WRITTEN SUMMARY OF ORAL REPRESENTATIONS

A46 Newark Bypass Scheme

The County Council's written summaries of oral representations
made during Issue Specific Hearings held December 2024

**Nottinghamshire
County Council**

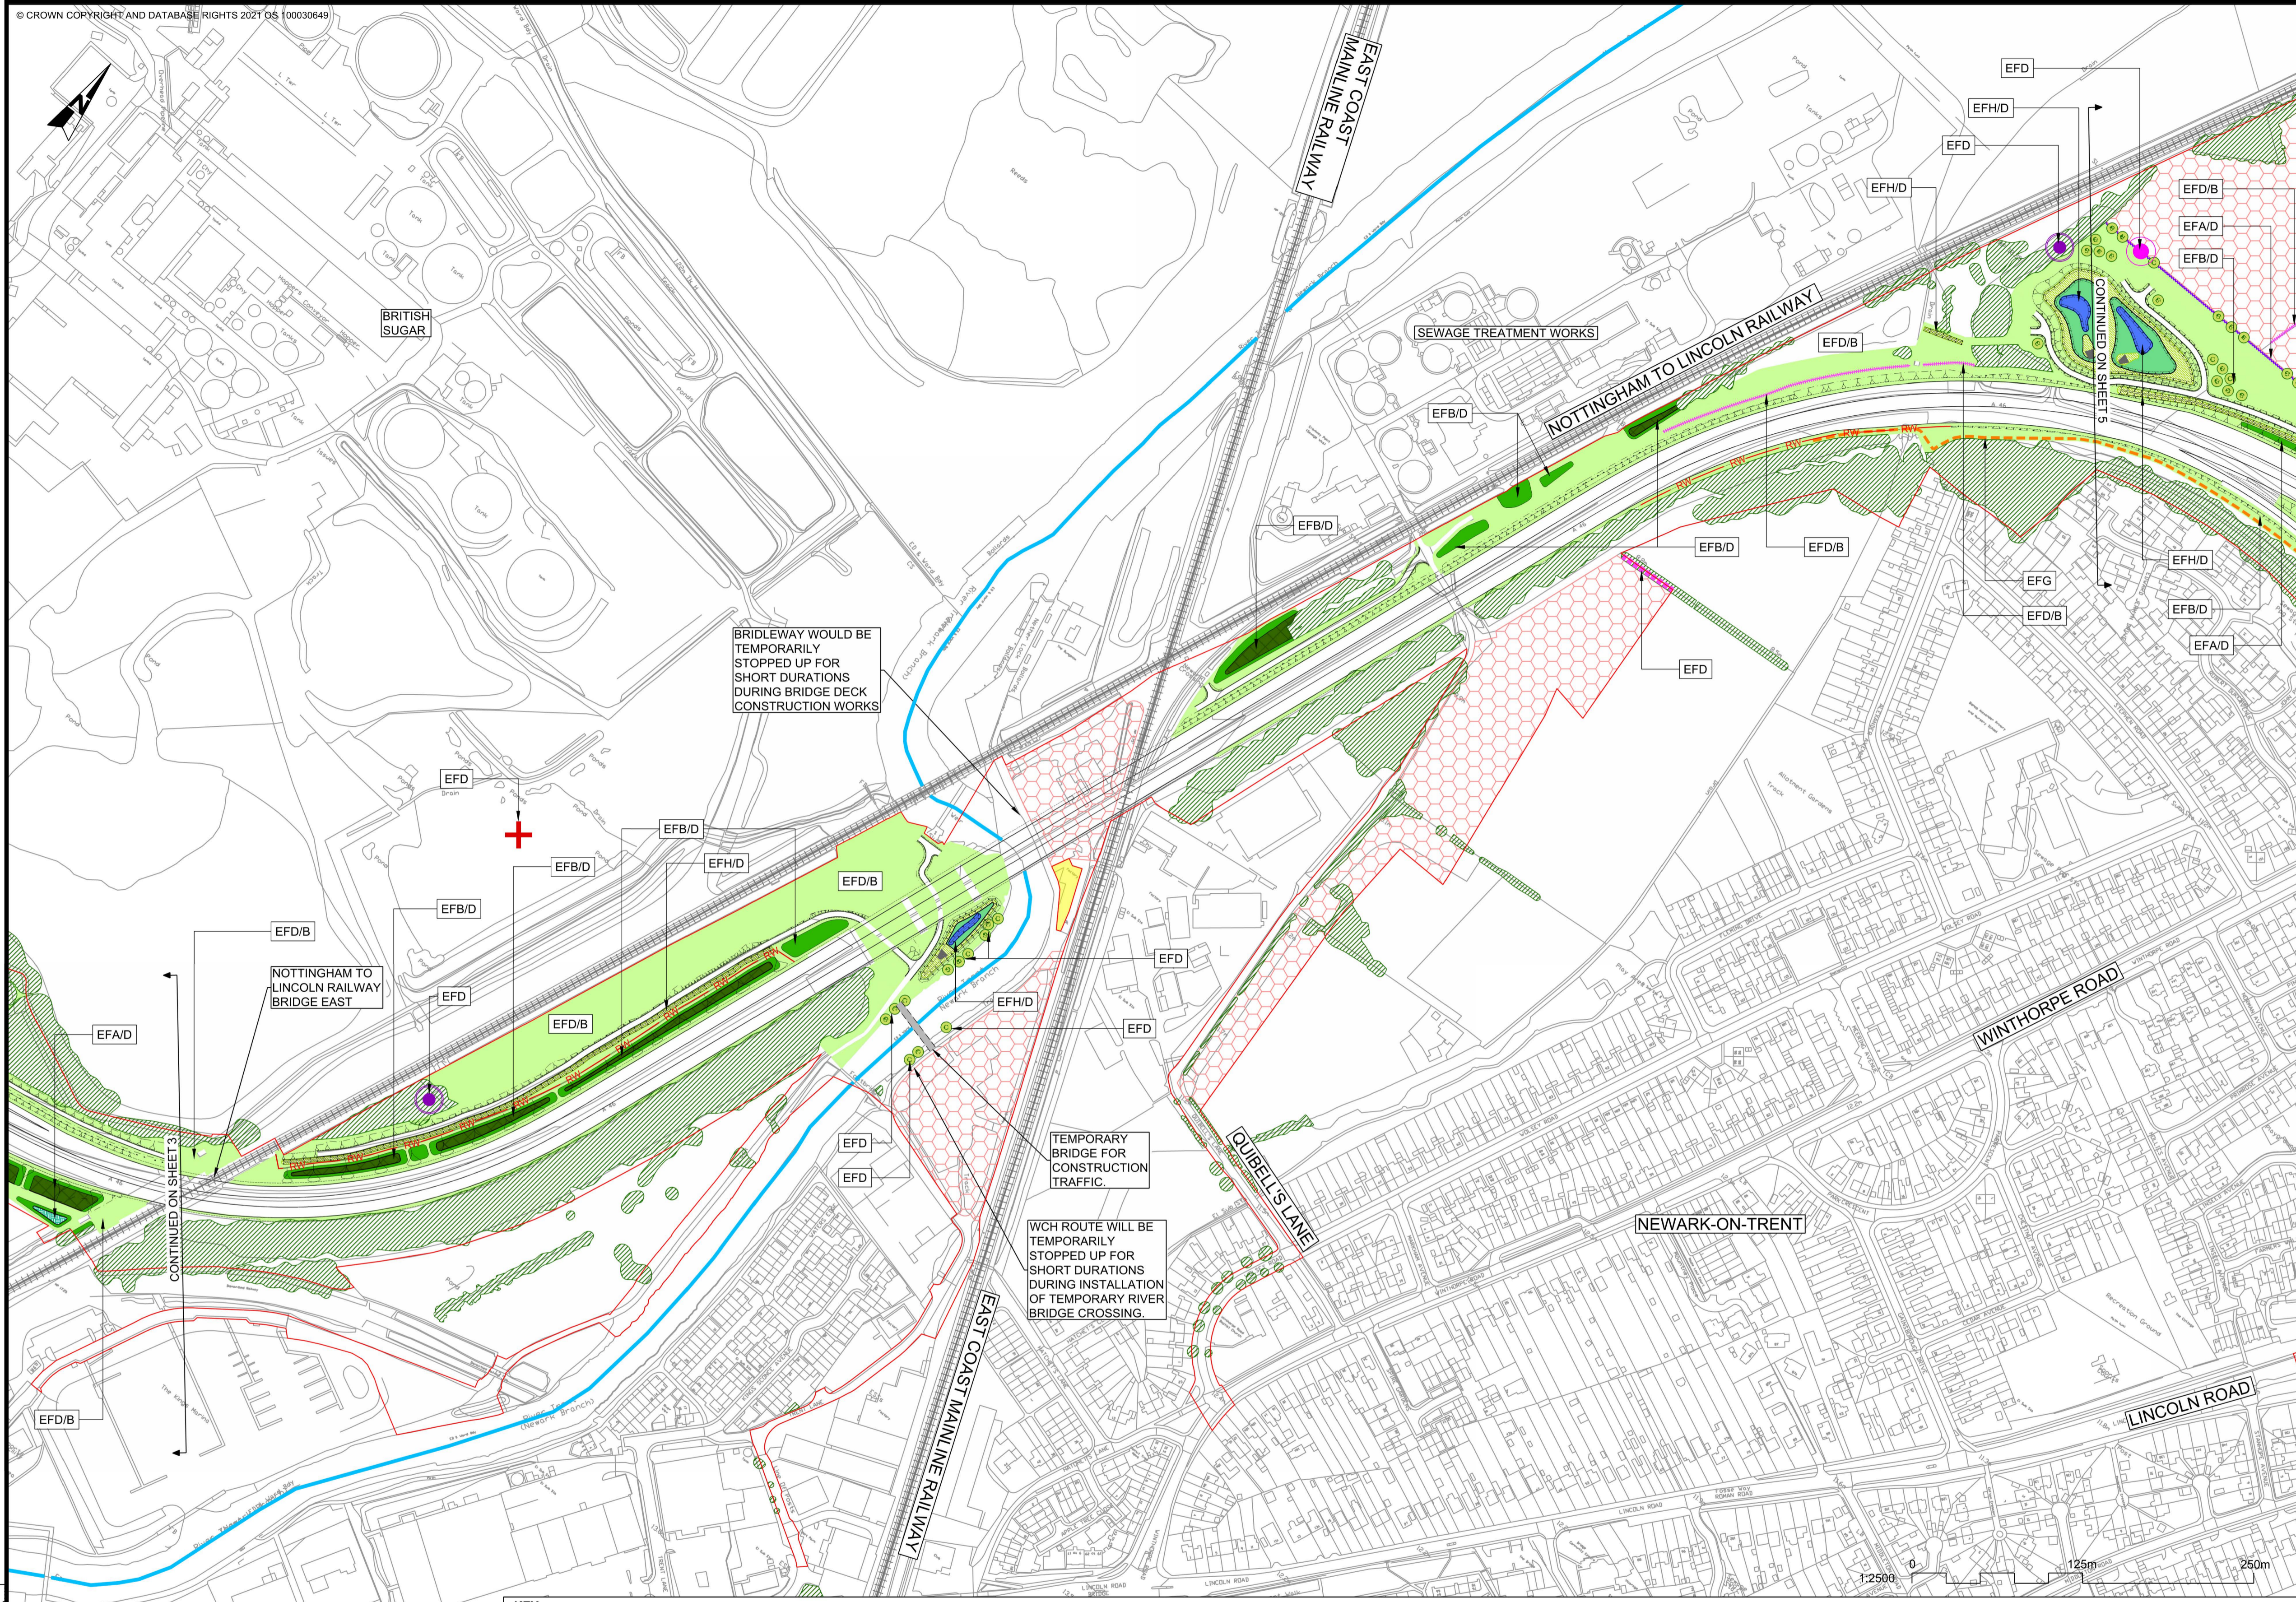
Sheet 2 of the Masterplan shows the two Farndon Borrow pits. The eastern pit is primarily to be open water (floodplain compensation) with marginal areas for biodiversity including some ponds. The western pit is to be restored to an area of reedbed, marsh/wet grassland and ditches/scrapes. Details are indicative but sufficient for now.
